AB/85/18/L

This application is for listed building consent for internal and external alterations to a property in the Arundel. The building is grade II listed and forms part of a terrace on the northern side of the road. Further, it is located within the Arundel Conservation Area.

Refrubishment of
16 Bond St
ARUNDEL, West Sussex.
Existing + Proposed Outhouse.
Scale 1:50 @ A3.

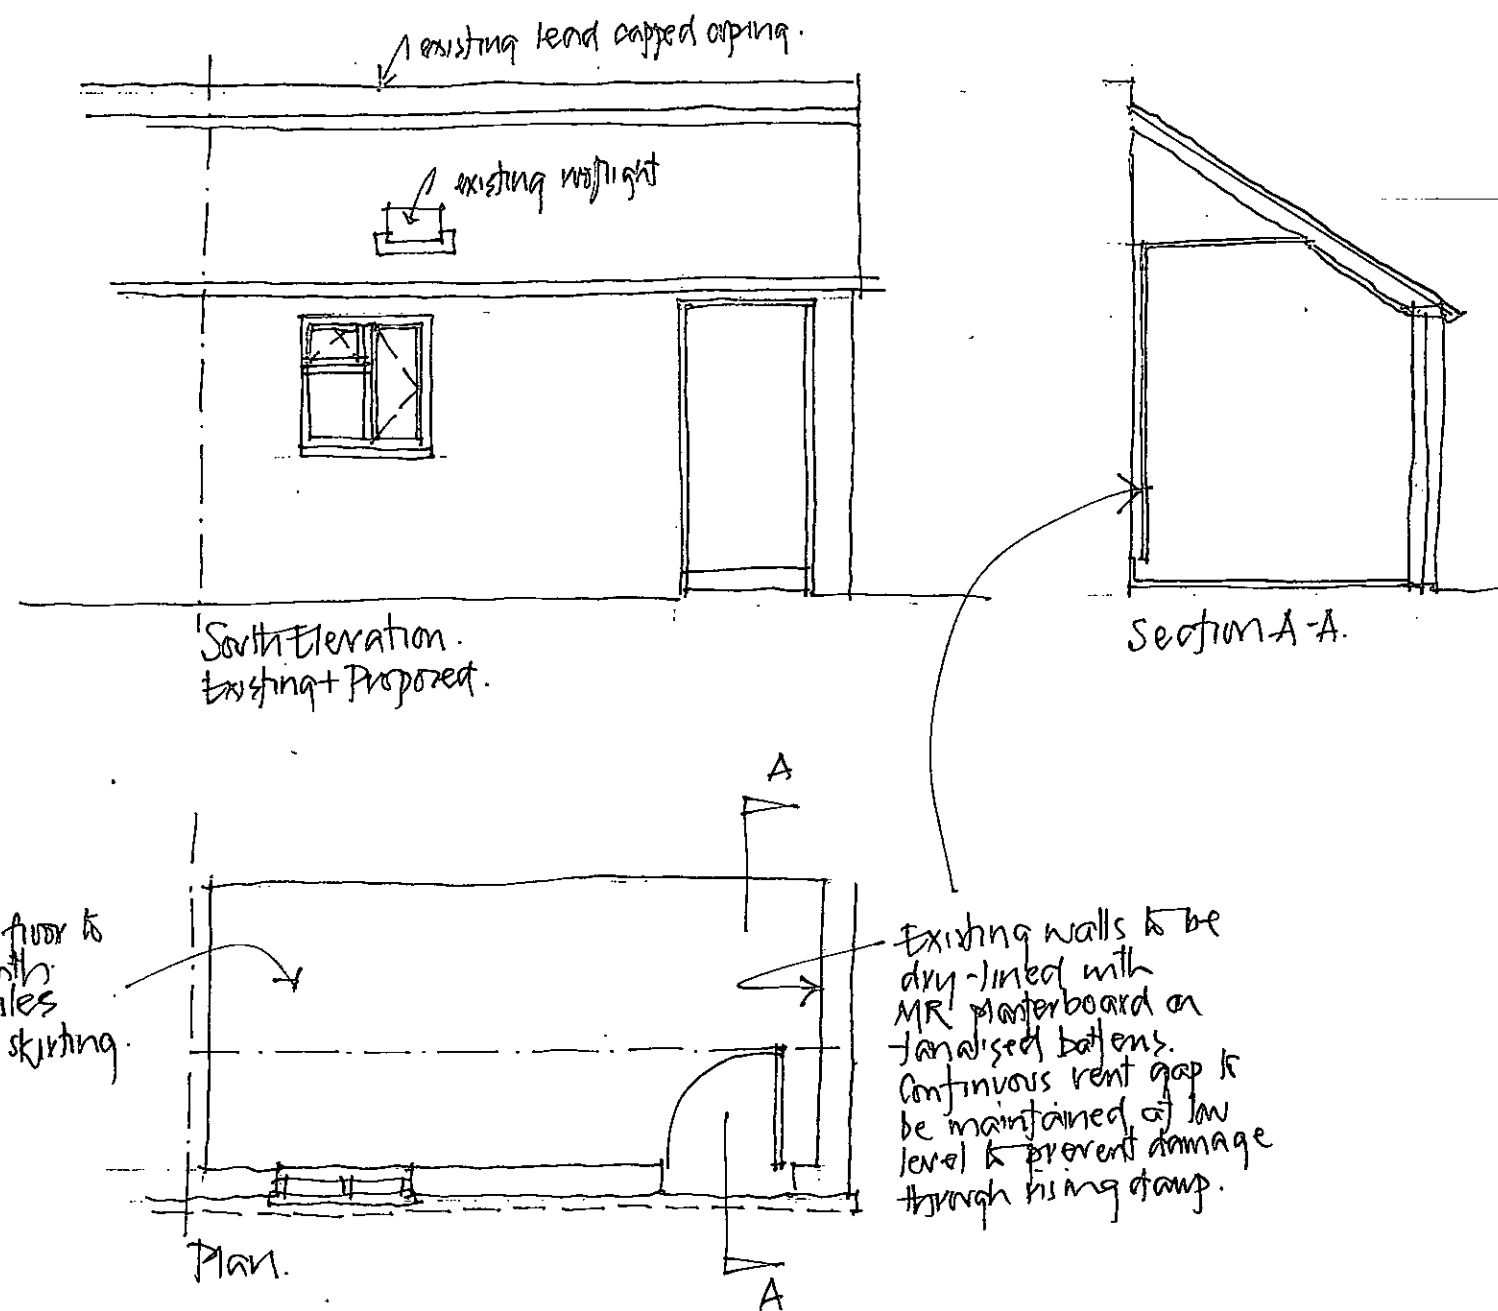
Outhouse: Works to the outhouse are considered will result in the removal of modern fabric which is not important to its character. Such works are considered to be acceptable, as long as they allow the building to 'breathe'.

Refurbishment of
16 Bond St.
ARUNDEL West Sussex.
Floor Plans - Proposed
Scale 1:50 @ A3

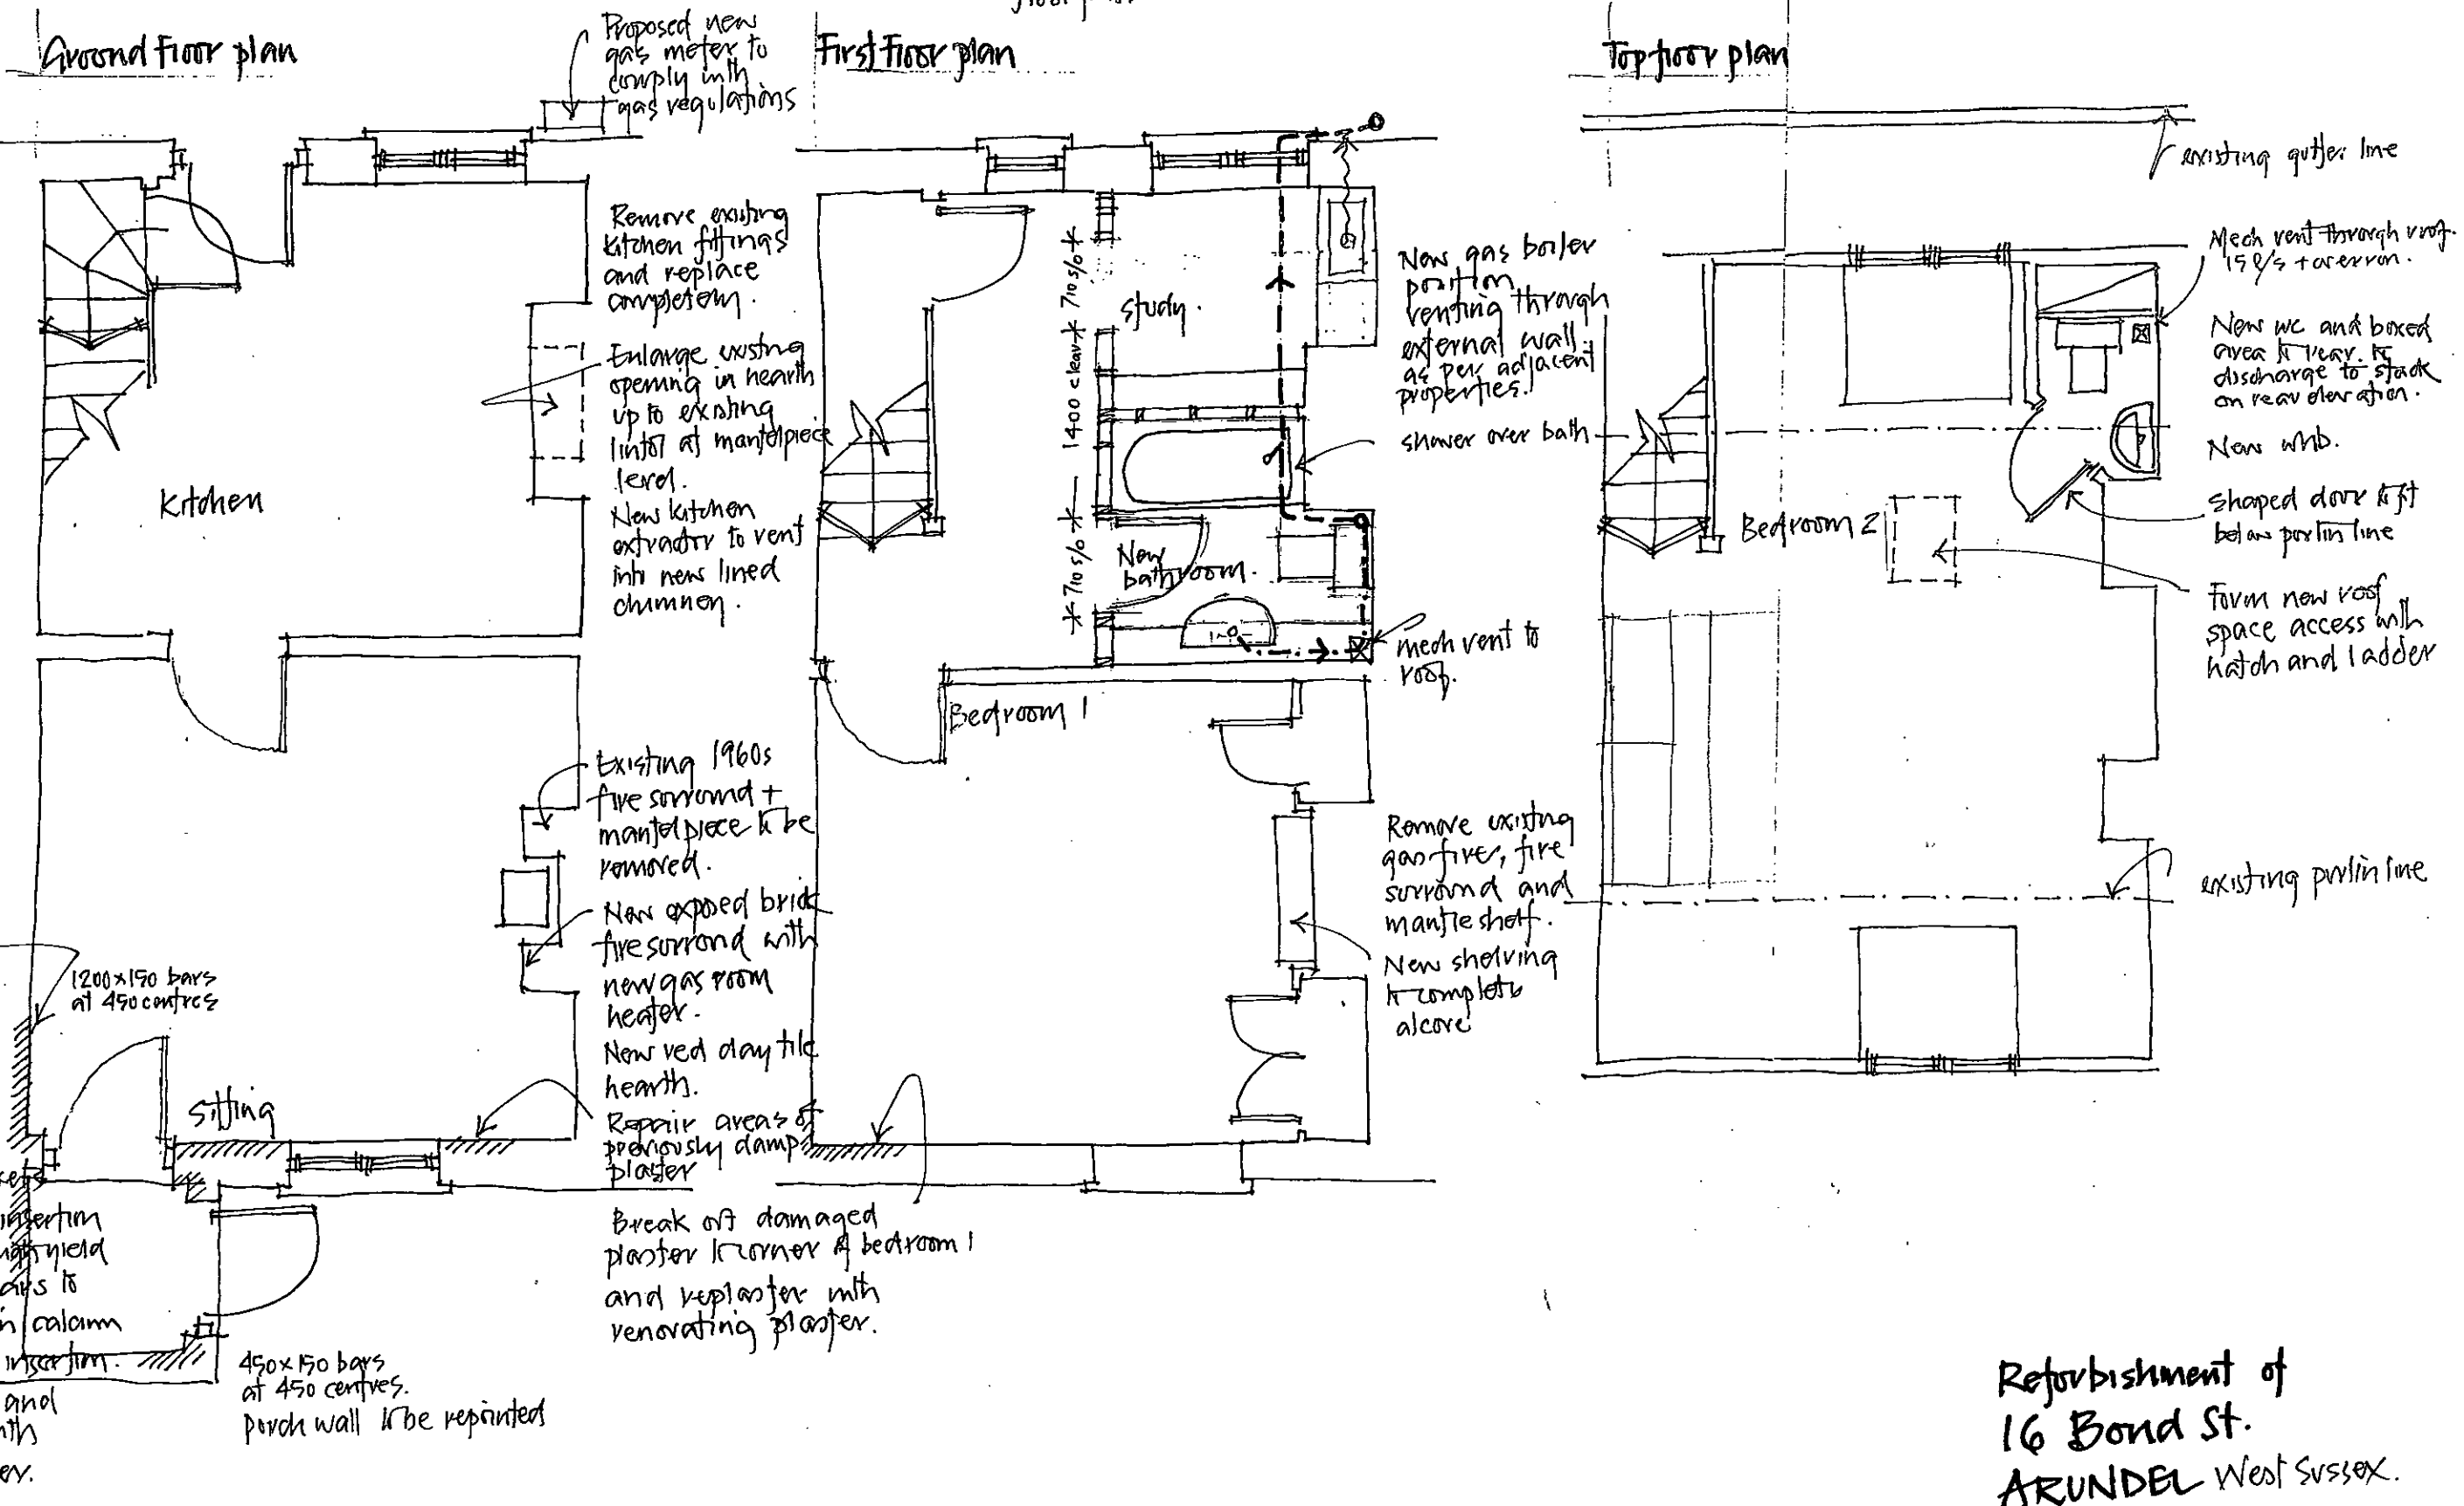
Ground floor: The 1950's hearth is not suitable for the property, and can be removed. I note from the Design and Access statement that the application proposes 'a traditional style wooden fire surround and a log-effect gas stove fire, to be more in keeping with the style of the property'. Such a proposal is supported, subject to details. Details of the surround should be provided before it is installed. This can be achieved by way of condition. However, I should point out that this conflicts with the proposed plans which indicates that the surround will be constructed from exposed brick. Which is correct?

First floor: It appears that the partition wall which serves the current bathroom was installed in the 1950's and is therefore of no significance to the building. Further, works in this location to provide for a smaller bathroom, and a small study appear to be acceptable. The pipework serving the new bathroom suite should use any existing pipe-runs and limit the amount of work to the flooring and joists.

Second floor: Both the installation of new En-suite bathroom and roof access are acceptable in principal. The pipework serving the new bathroom should use any existing pipe-runs and limit the amount of work to the flooring and joists. Details of the new door should also be provided by way of condition.

Details of the replacement fire surround in the sitting room and bedroom 1

Details of the door for the En-suite

Refrurbishment of.
16 Bond St.
ARUNDEL. West Sussex.
Existing Elevations
Scale 1:50 @ A3

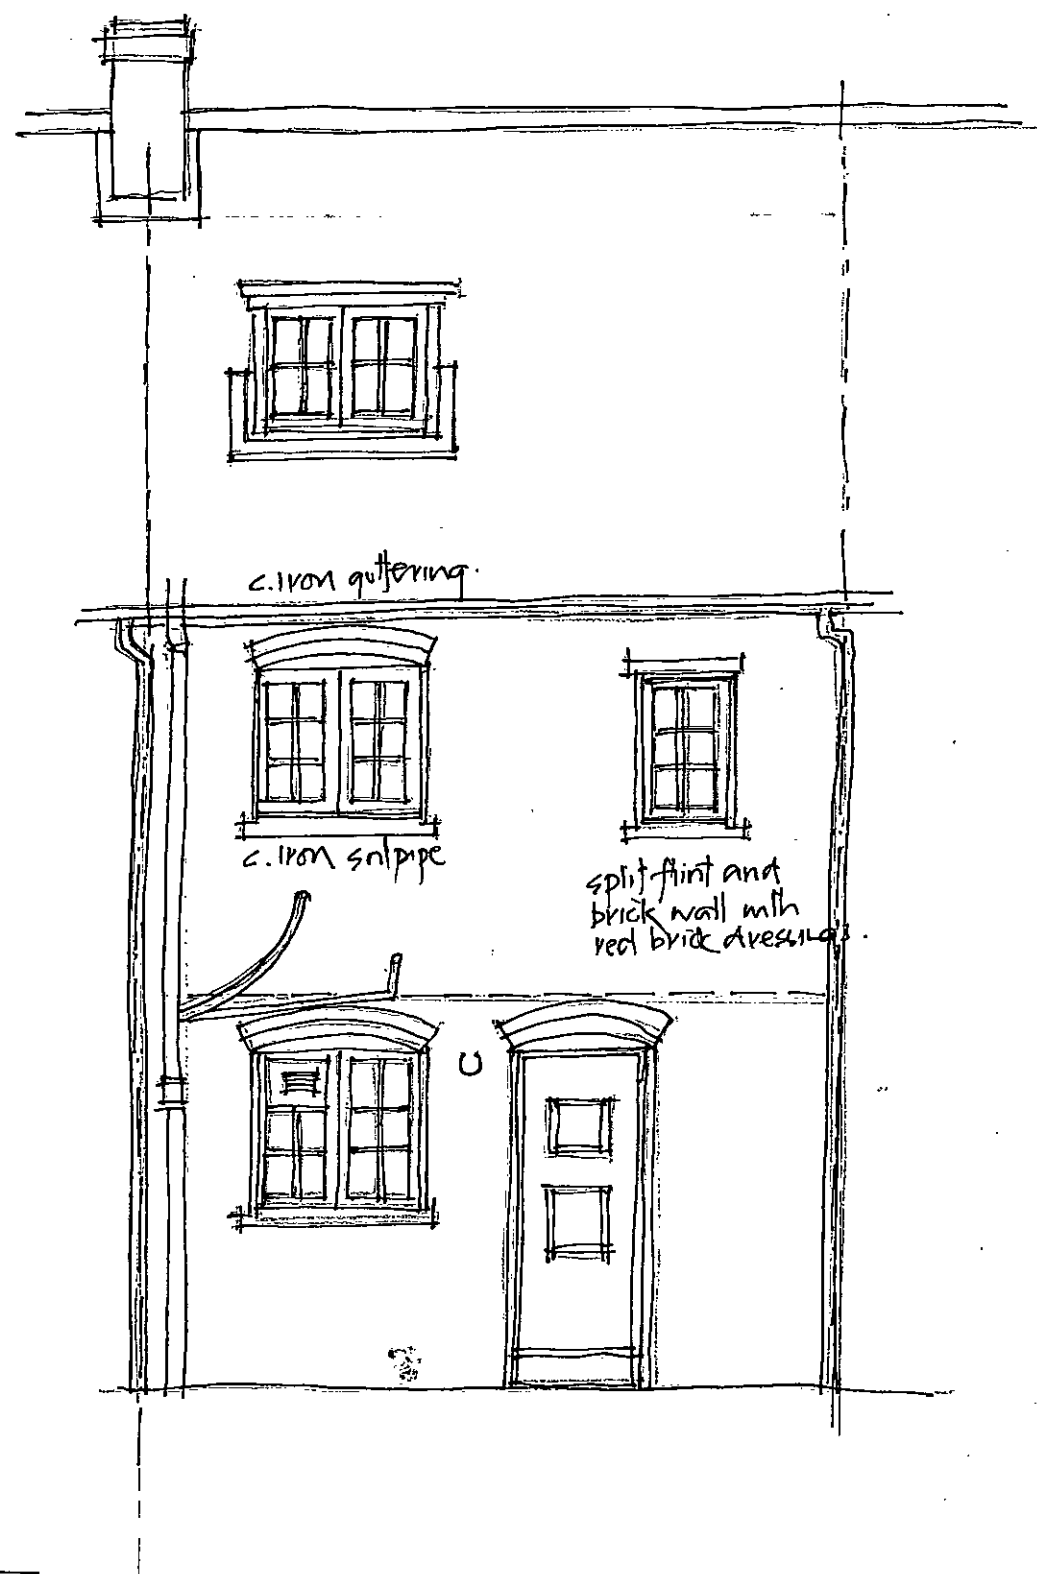
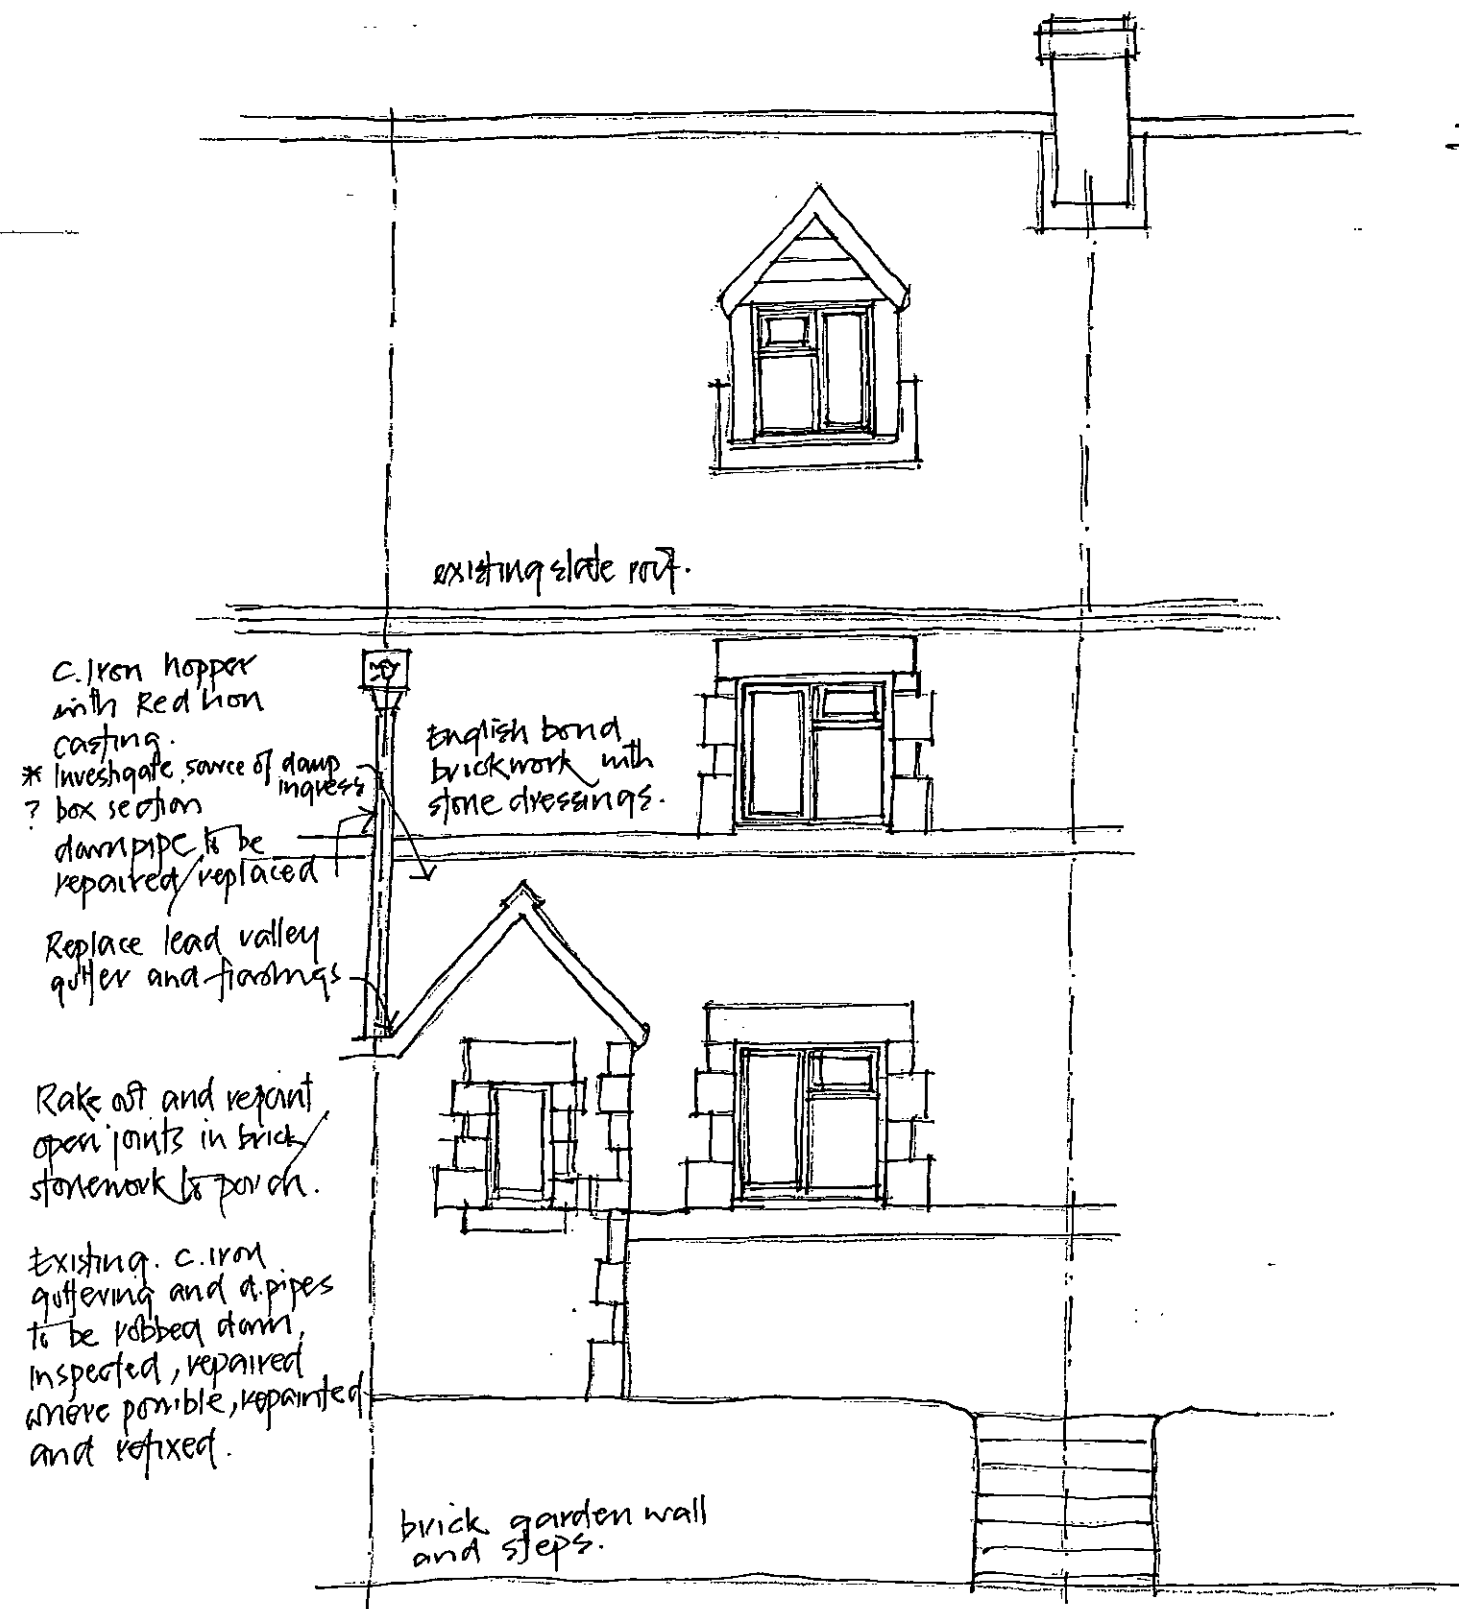
Externally all of the existing iron guttering should be repaired first, before being replaced. Ideally replacement guttering and down pipes should match existing materials, but it is considered that alternative materials may be acceptable subject to details of their design/quality.

The proposal to replace two of the existing front windows (which are of an inappropriate design) is supported. However, further information would need to be provided in order to ensure that they would respect the traditional windows found elsewhere on the terrace.

Details of the replacement guttering/downpipes
